ExQ3	Question to:	Question:	East Suffolk Council Response:
DCO.3 Draft Development Consent Order (DCO)			
DCO.3.0	The Applicant	In the redrafting of the CoCP for D7, has the substance of any of the commitments been changed? To take an example, in Part C, section 8 (Historic Environment) the whole of section 8.2 has been deleted and a new para 8.1.4 inserted. It seems to the ExA that the effect of 8.2 is now contained in para 8.1.4. Is this the intention and effect?	
DCO.3.1	The Applicant	(a) At para 1(4) of Sch 2 (reqts) of the dDCO Revision 8 the Applicant has deleted the word “substantively” from “substantively consistent” and also deleted the words “and in a manner that does not give rise to any materially new or materially different environmental effects to those assessed in the environmental information”. Please will the Applicant explain the reason for the latter deletion. Is it inevitable that works to be carried out in general accordance with details etc will, if they are simply consistent with those details etc not give rise to materially new / different effects? (b) However, the ExA is finding it more difficult to understand the Applicant’s reluctance to abandon the use o

DRAWING NO:
SZC-SZ0100-XX-000-DRW-100205

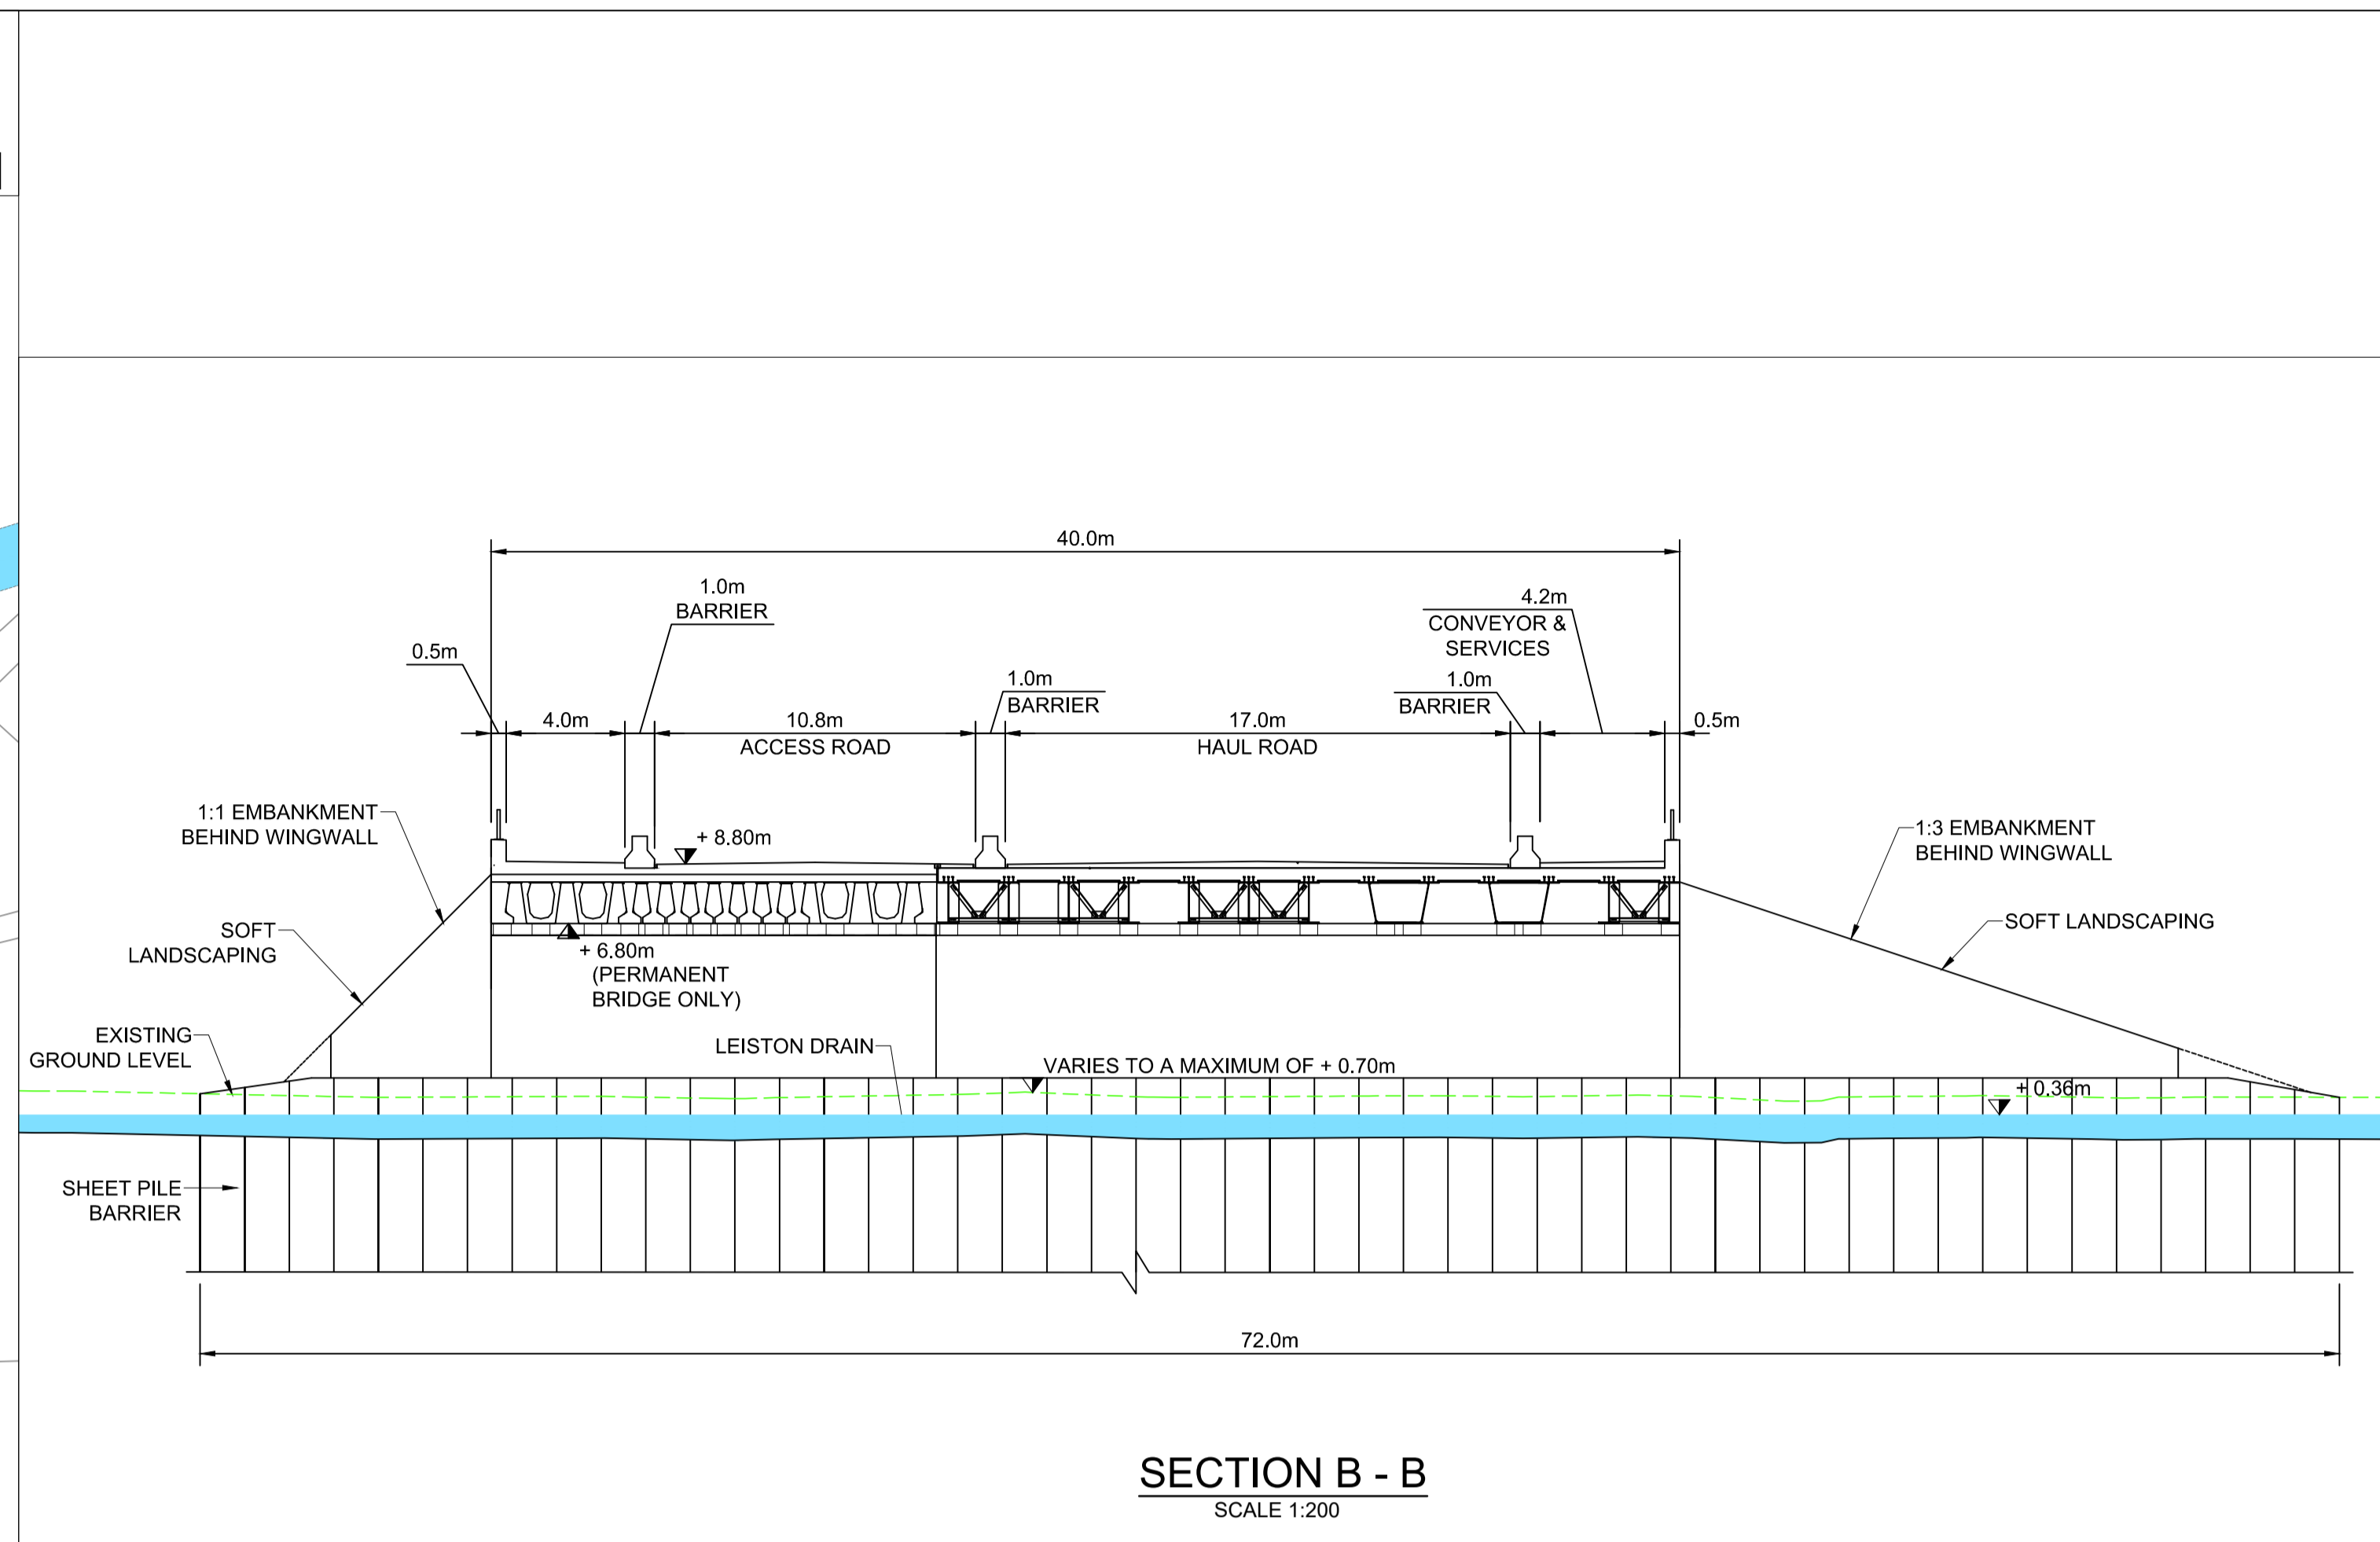
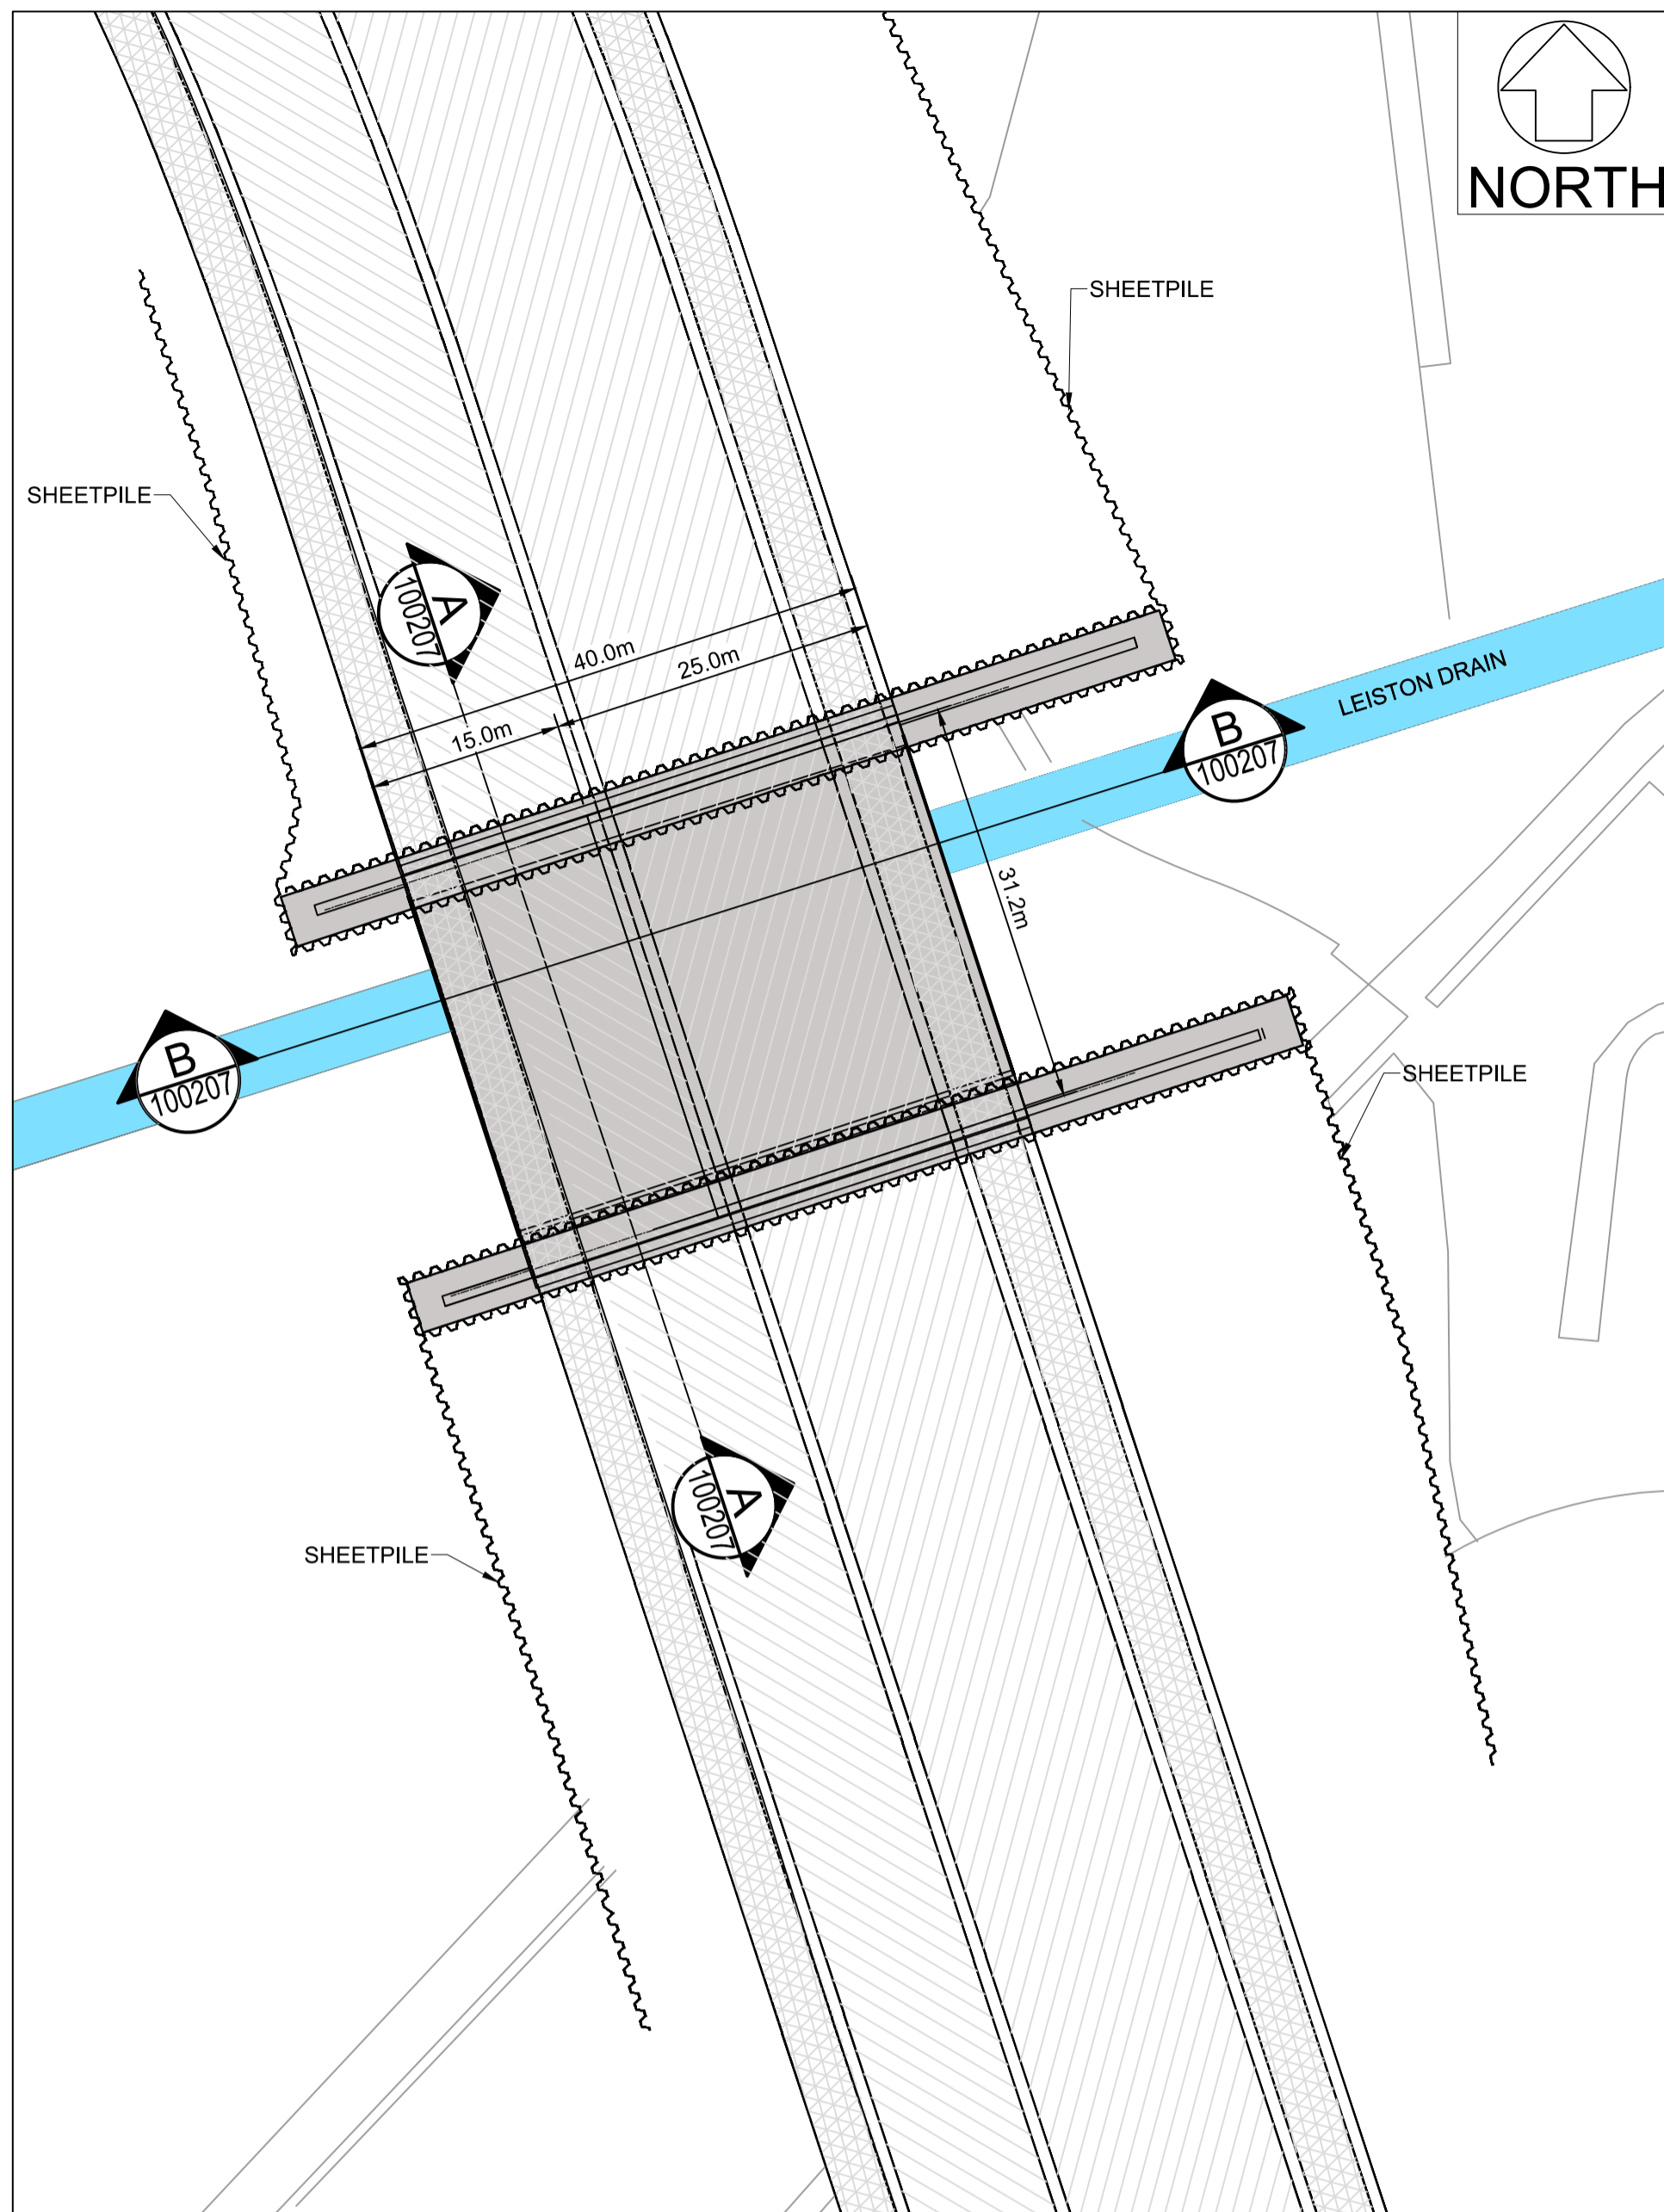
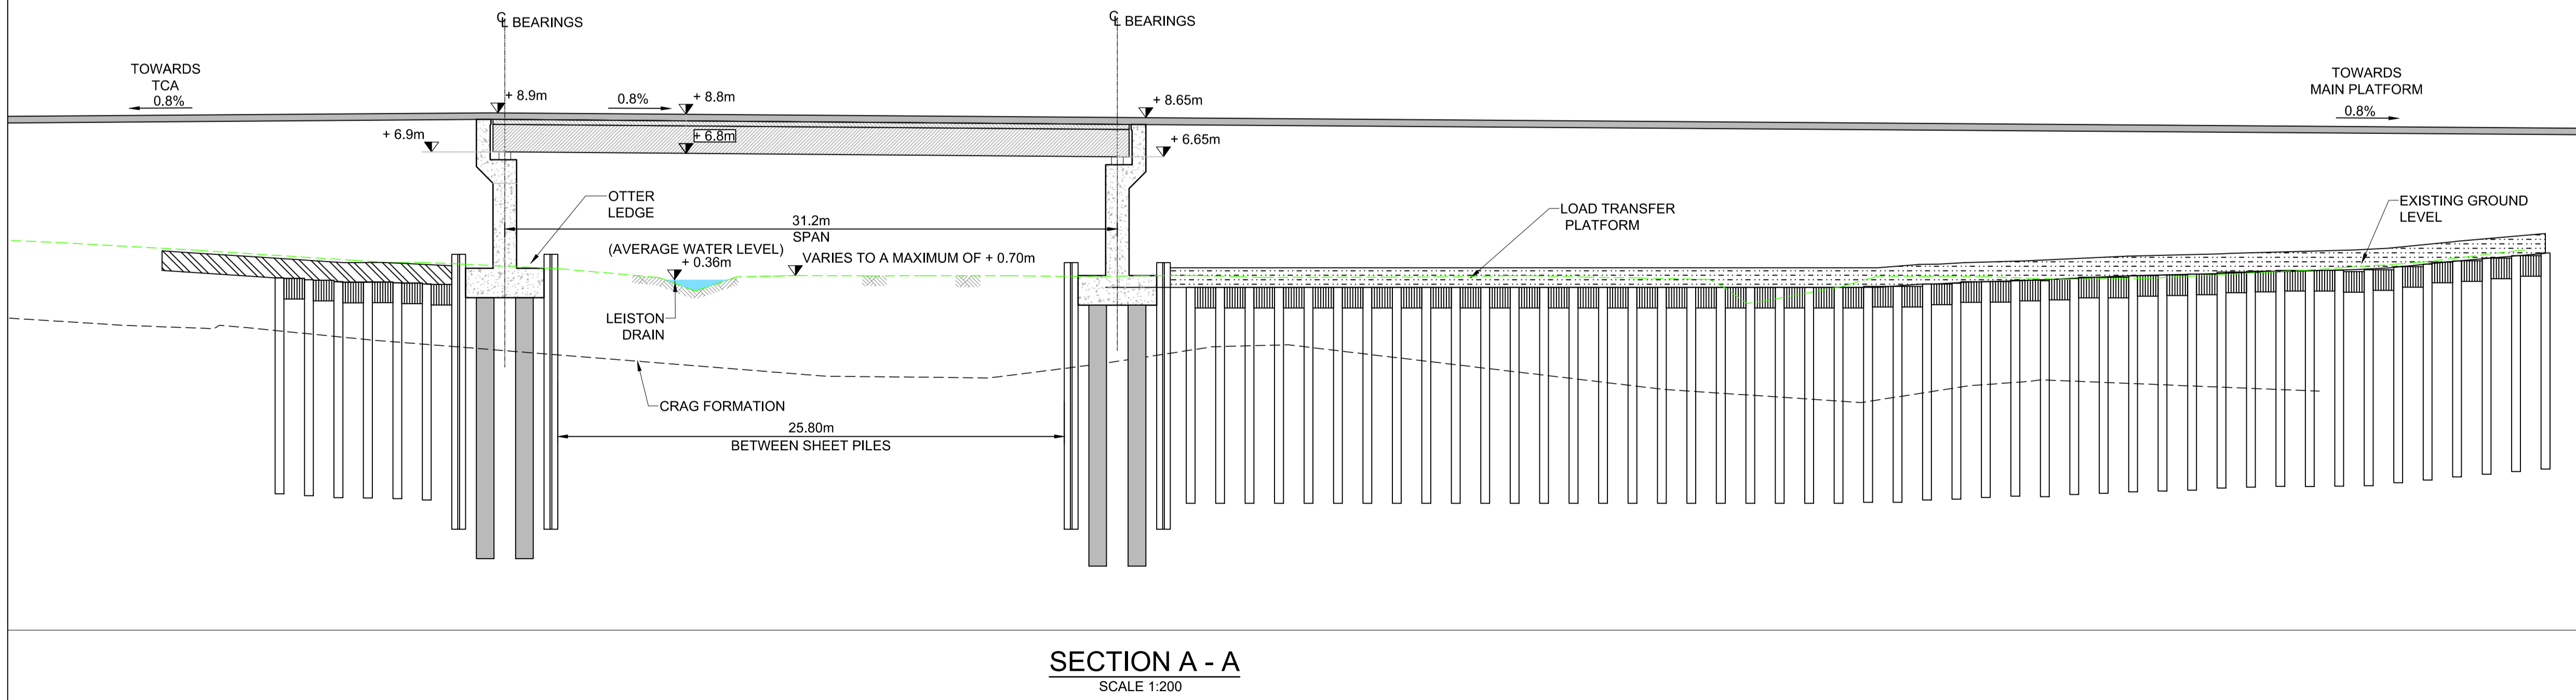
LI.3.4	Applicant	SSSI Crossing The content of Principle 79 of the Detailed Built Development Principles [REP5-070] is noted. However please further expand on how the colour selection of the hard elements of the SSSI crossing, visible from public viewpoints, has taken into consideration the advice contained in 'Guidance on the Selection and use of Colour in Development' published by the Suffolk Coast and Heaths AONB?	
LI.3.5	Applicant	Main Development Site –
